## RESPONSE TO REVIEW COMMENTS

### **WALDEN PRESERVE 2 – AMENDED PUD DEVELOPMENT PLAN PUD-18-007**

LAND RESOURCE ASSOCIATES

March 11, 2019

Sheet number
1 OF SIX

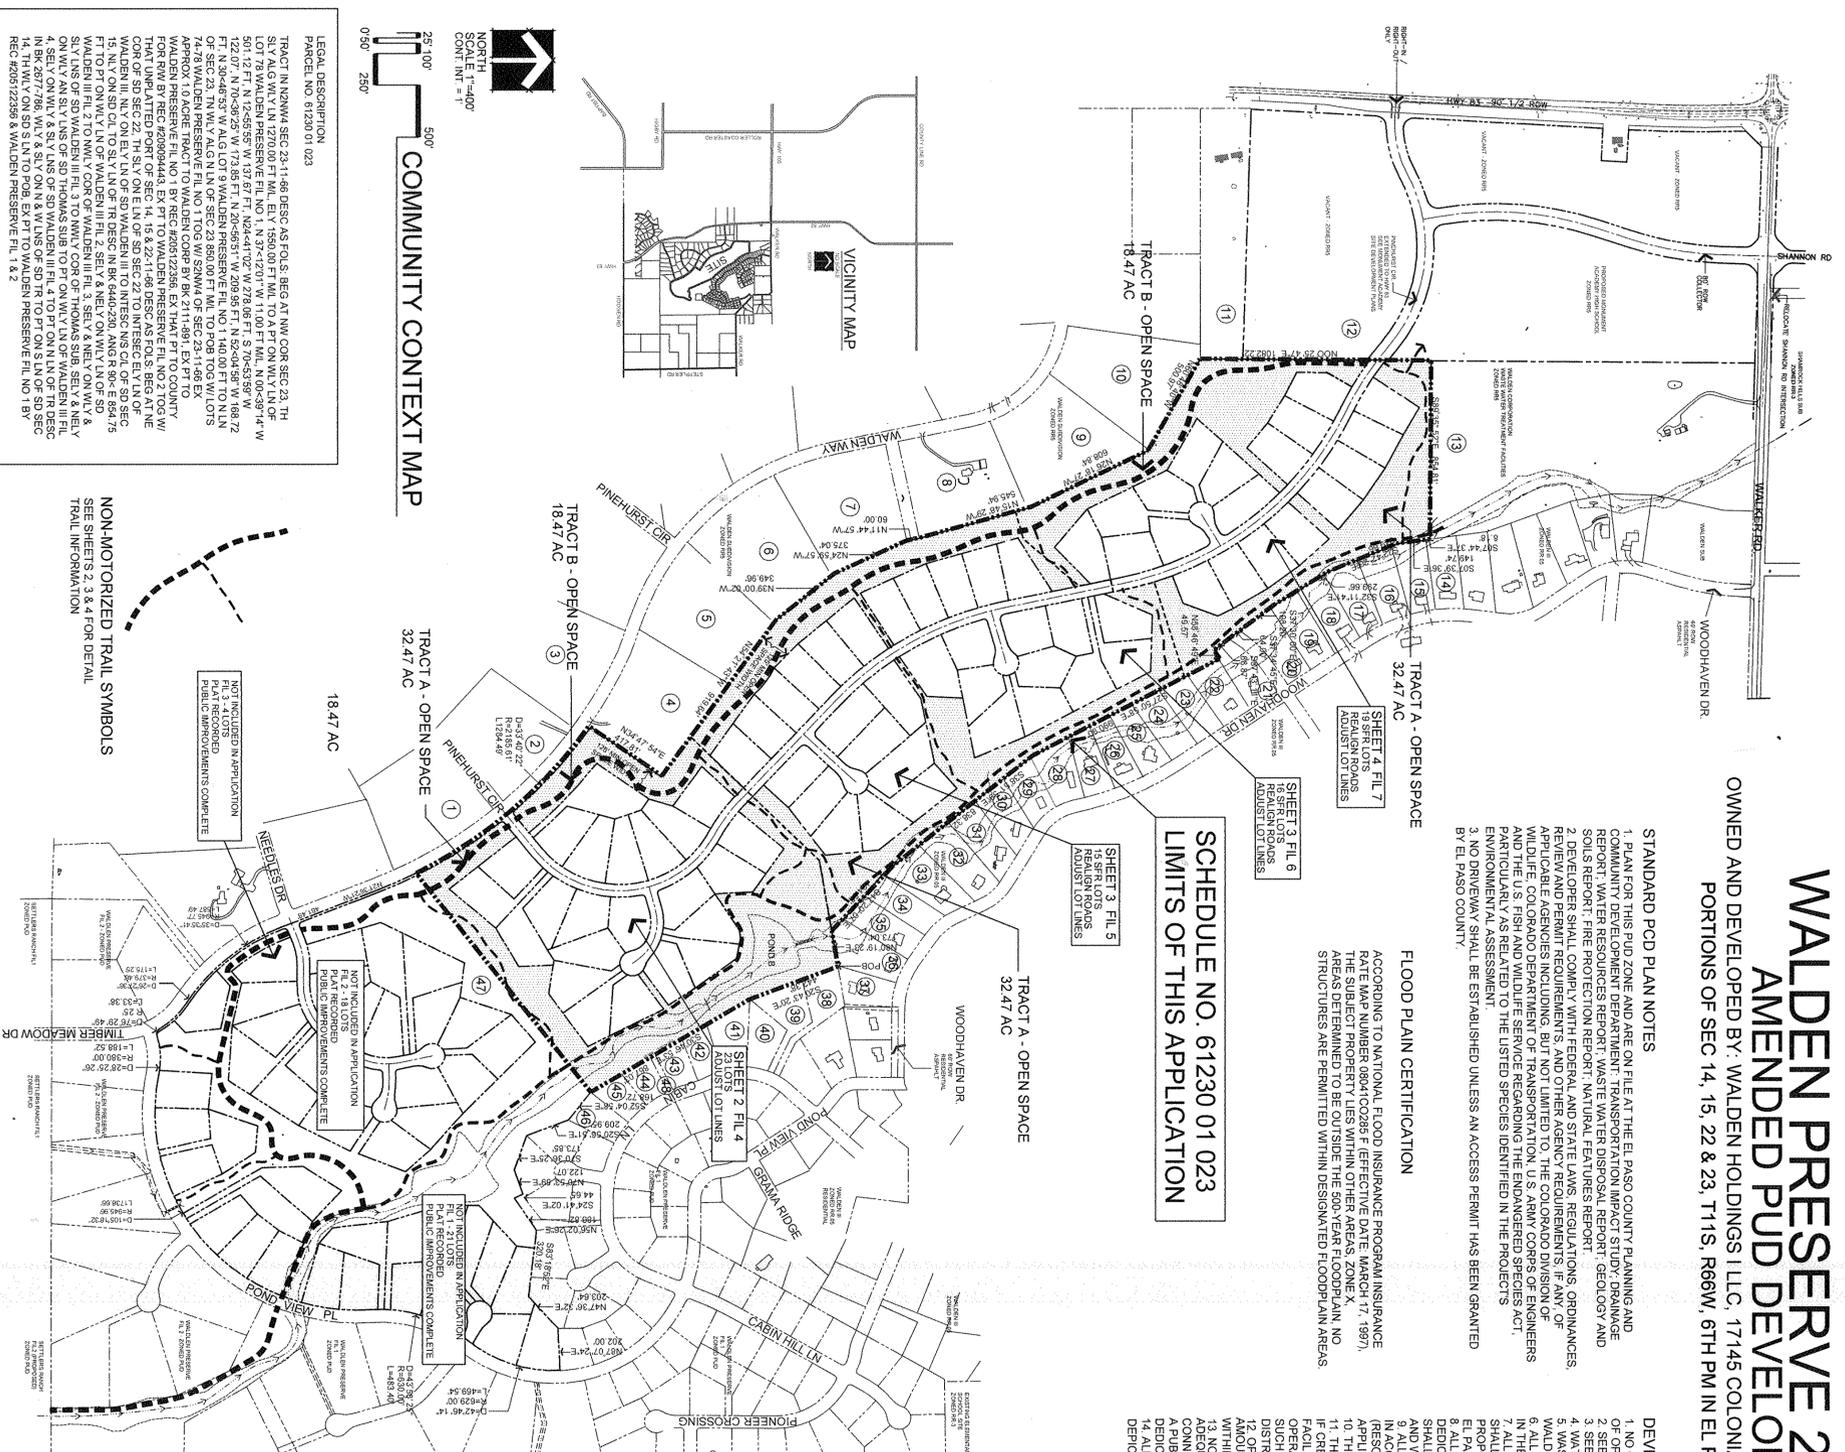
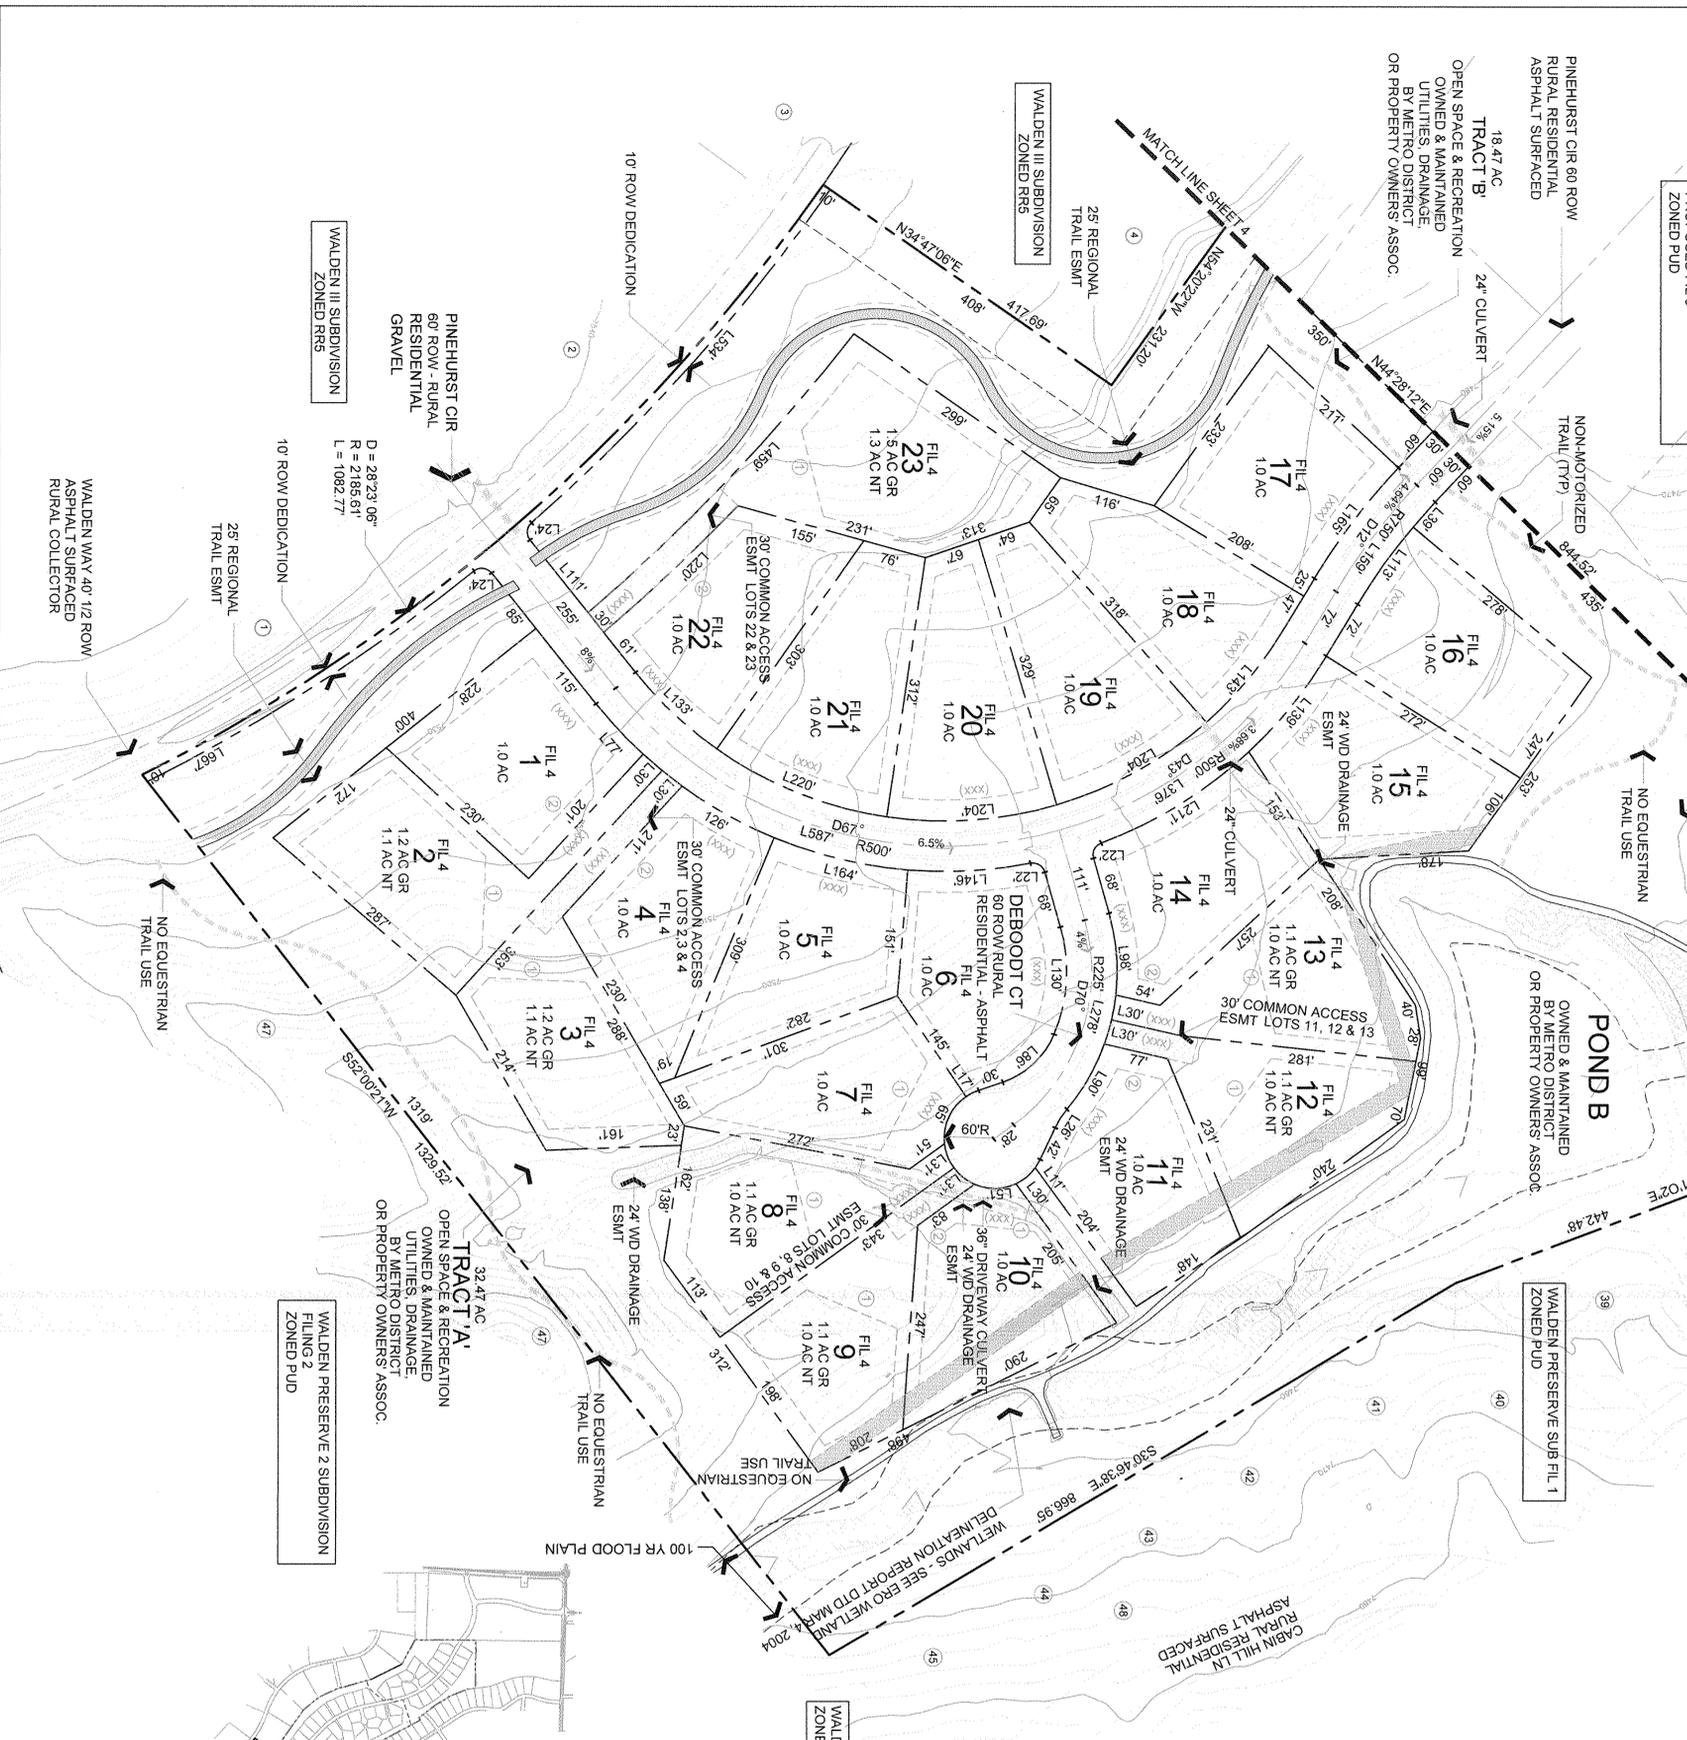
Sheet 1 – *Area included in change* - As the scope of the proposed PUD Development Plan amendments has increased, all areas within the application (parcel no. 6123001023 as illustrated on Sheet 1) have been modified to one extent or another and are now included with the area of the PUD amendments.

Sheet 1 – *Not included for the PUD as shown* – Note has been modified and the Adjoining Owners List included on Sheet 2 has been expanded to include all owners adjoining the expanded PUD area. The mailing notifying the adjoining owners has been re-mailed to the expanded list.

Sheet 1 – *Is this a carryover note...done* – All notes that are no longer applicable to this application have been removed.

Page 1 – *Much of the detail that was on the 2016 PUD has been lost with the dark hatching* – The hatching has been lightened.

Page 1 – The callout seems to be in the wrong area – This callout has been removed due to the expansion of the PUD amendment area.

Page 1 – *Please cloud all areas being amended* – As the scope of the proposed PUD Development Plan amendments has increased, all areas within the application (parcel no. 6123001023 as illustrated on Sheet 1) have been modified to one extent of another and are now included within the PUD Development Plan amendment area.

sheet number: 2 OF SIX
PDD FILE NO: PUD-18-007

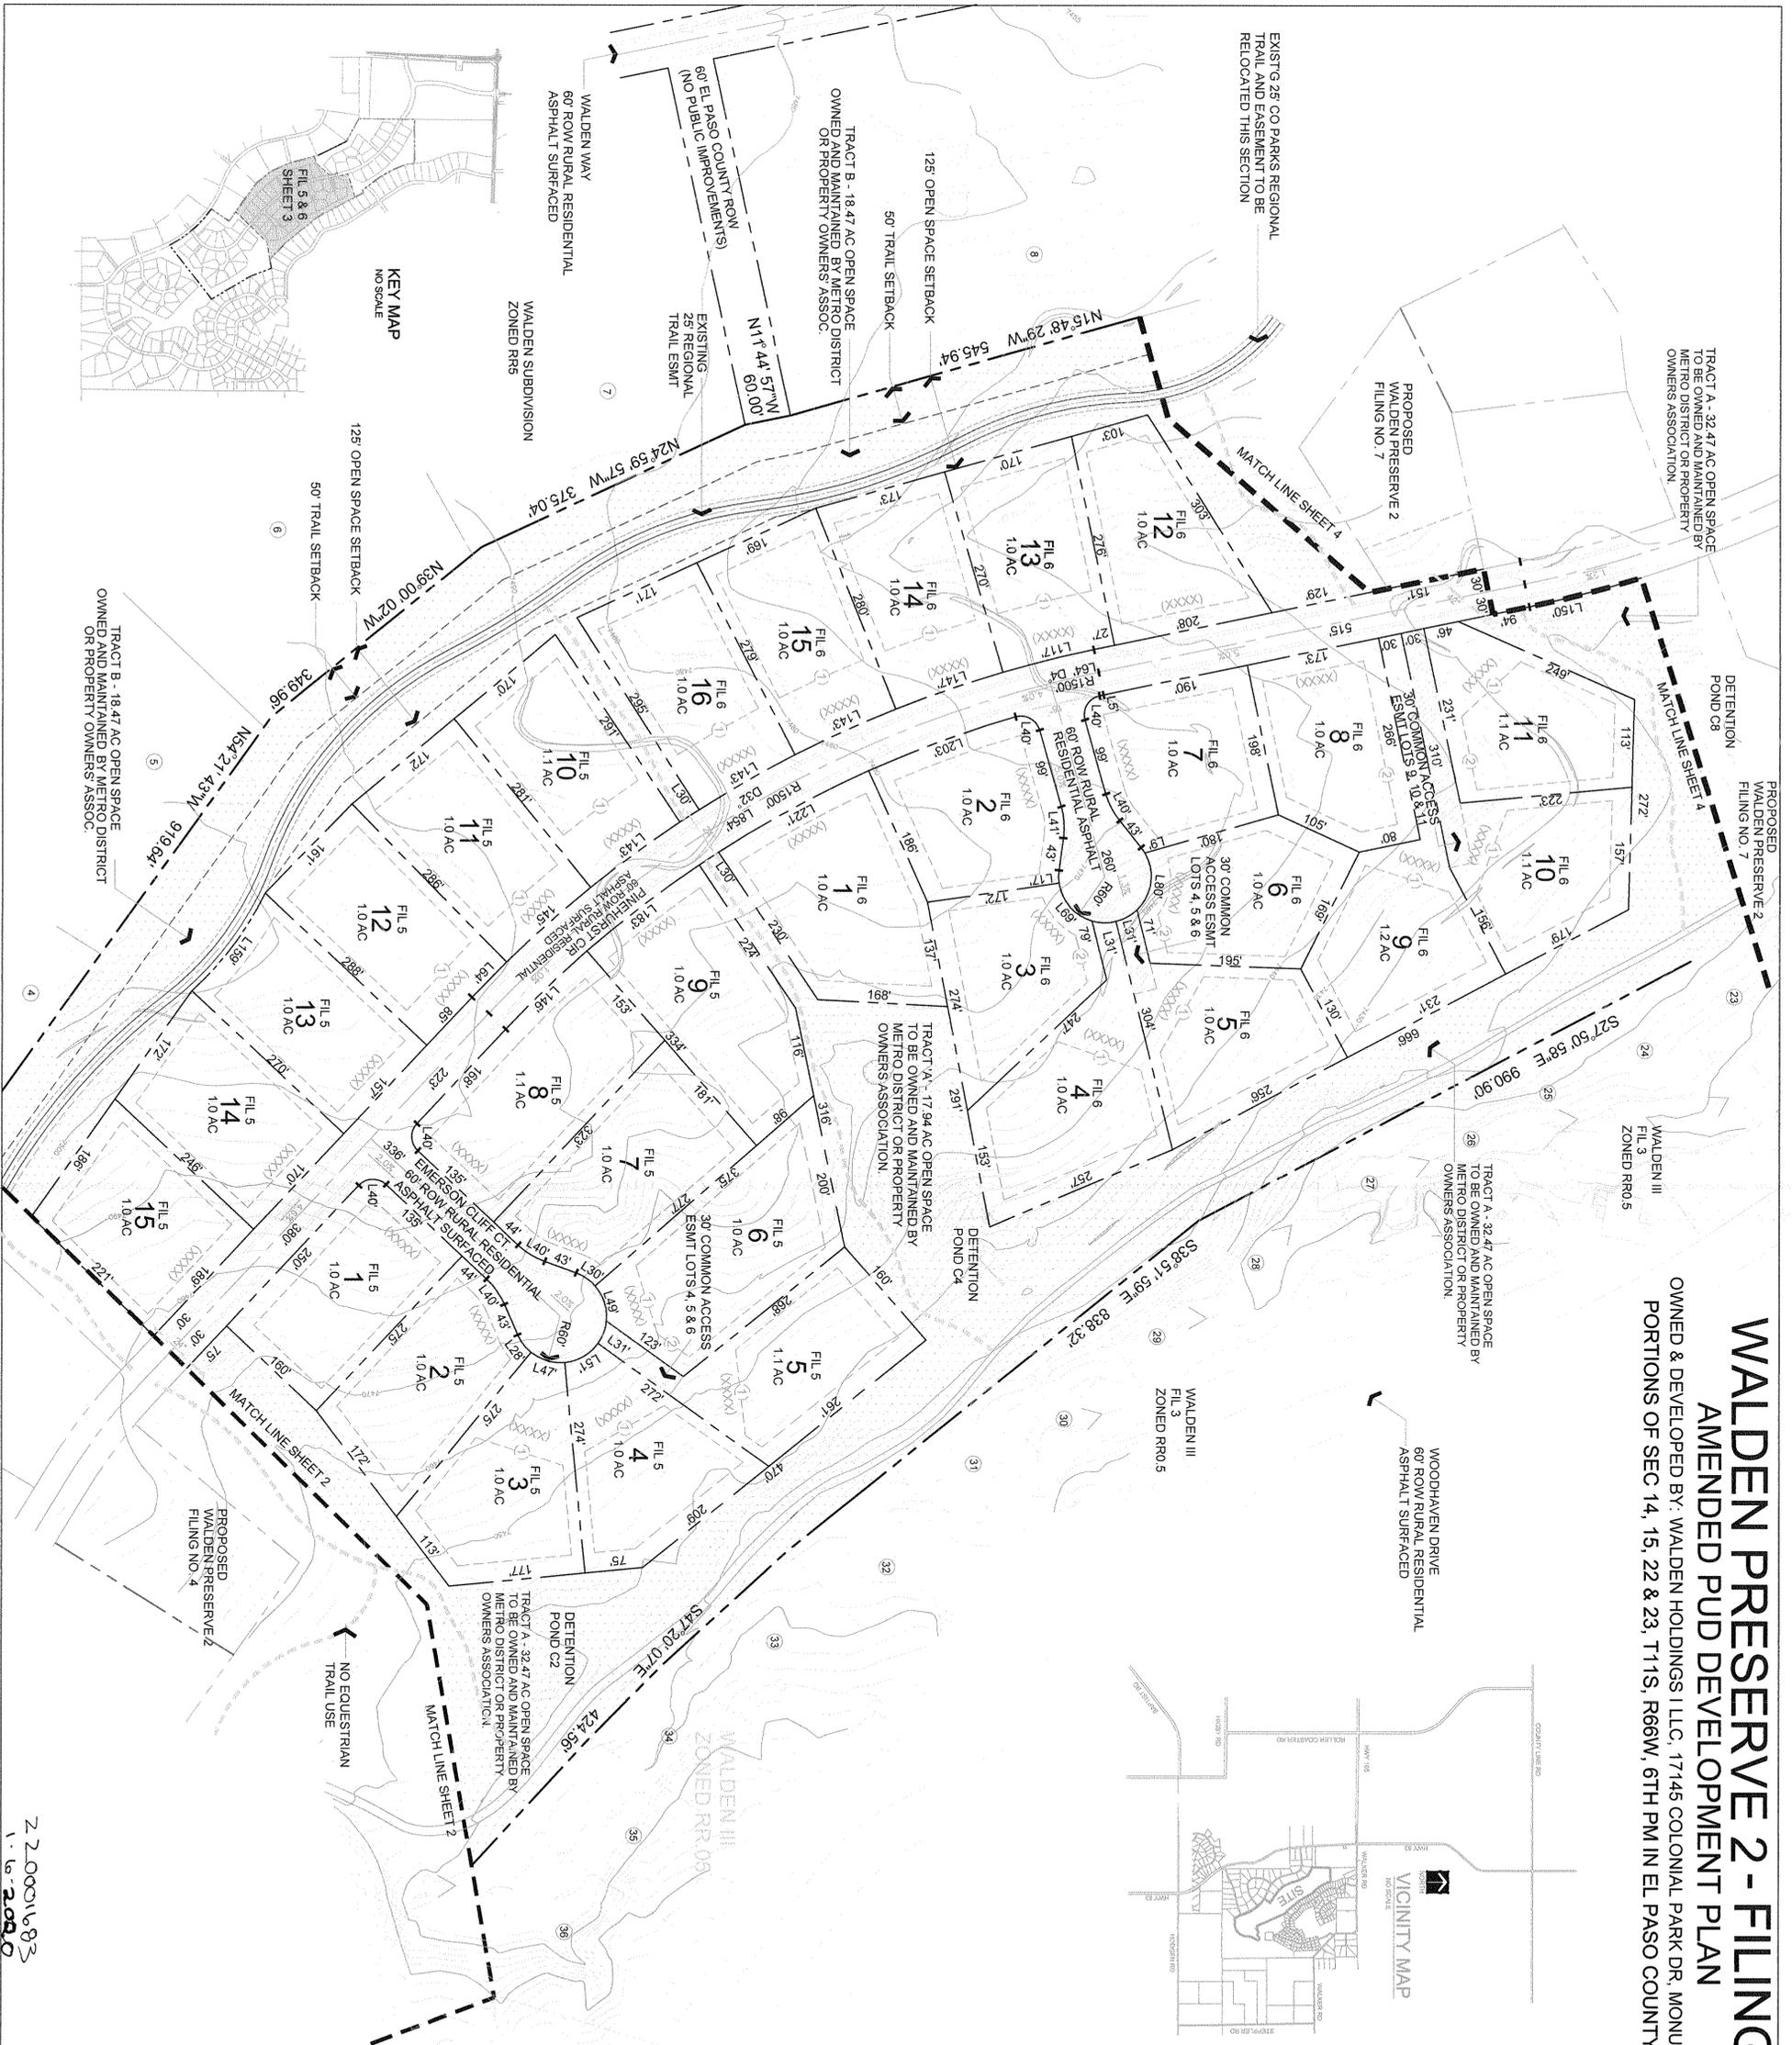
Sheet 2 – Please add the land use per the zoning checklist – The adjoining owners list has been expanded to include zoning for each parcel and land use for each parcel.

Sheet 2 (and Sheets 3 thru 4) – *Driveway access to more than 3 lots* – All lots containing a combined access (driveway) easement have been limited to accessing a maximum of 3 lots with the included lot numbers identified on the drawings.

Sheet 2 (and Sheets 3 thru 4) – *It is difficult to identify what information is being provided* – In an effort to clarify the plans; (1) the contours have been significantly lightened, (2) the hatch lines have been lightened, (3) standard lot line easements have been removed in favor of a plan note identifying all standard lot line easements, (4) building setback lines have been lightened.

Sheet 2 (and Sheets 3 thru 4) – *What are these various line items* - The line items include the property line, standard lot line easements and building setbacks. For greater clarity, the standard lot line easements have been removed in favor of a plan note identifying all standard lot line easements. The standard building setback lines include 25' front, side and rear building setbacks. Non-standard building setbacks are identified by number and shown in the Symbol Legend on each sheet and include (1) front yard setback at a minimum of 150' lot width and (2) increased 25' side yard building setbacks utilized where standard lots adjoin flag stems.

Sheet 2, 3 and 4 – *issues related to combined access (driveway) easements* – The intent is to provide combined driveway access for up to three lots. Access easements must touch or adjoin any lot being provided common driveway access. Where an easement provides access to 2 lots, the easement is centered on the lot's common property line flag stem and is 30' wide. Where an easement provides access to 3 lots, the access easement is configured such that 30' of the easement width is contained within the flag stem adjoining the non-flag lot being provided access and an additional 15' of width is provided within the adjoining flag stem for a total of 45' of easement width. This technique allows for the actual driveway being centered upon the common flag stem property line while providing legal access to all 3 lots involved. Specific easement locations, widths and lots being accessed by the combined access easement are identified on the Preliminary Plan. Provisions related to common driveway use rights and maintenance requirement and responsibilities are contained within the subdivision's Restrictive Covenants and are consistent with Filings No. 1 through 3. The Walden Preserve 2 Restrictive Covenants are included within this re-submittal package.
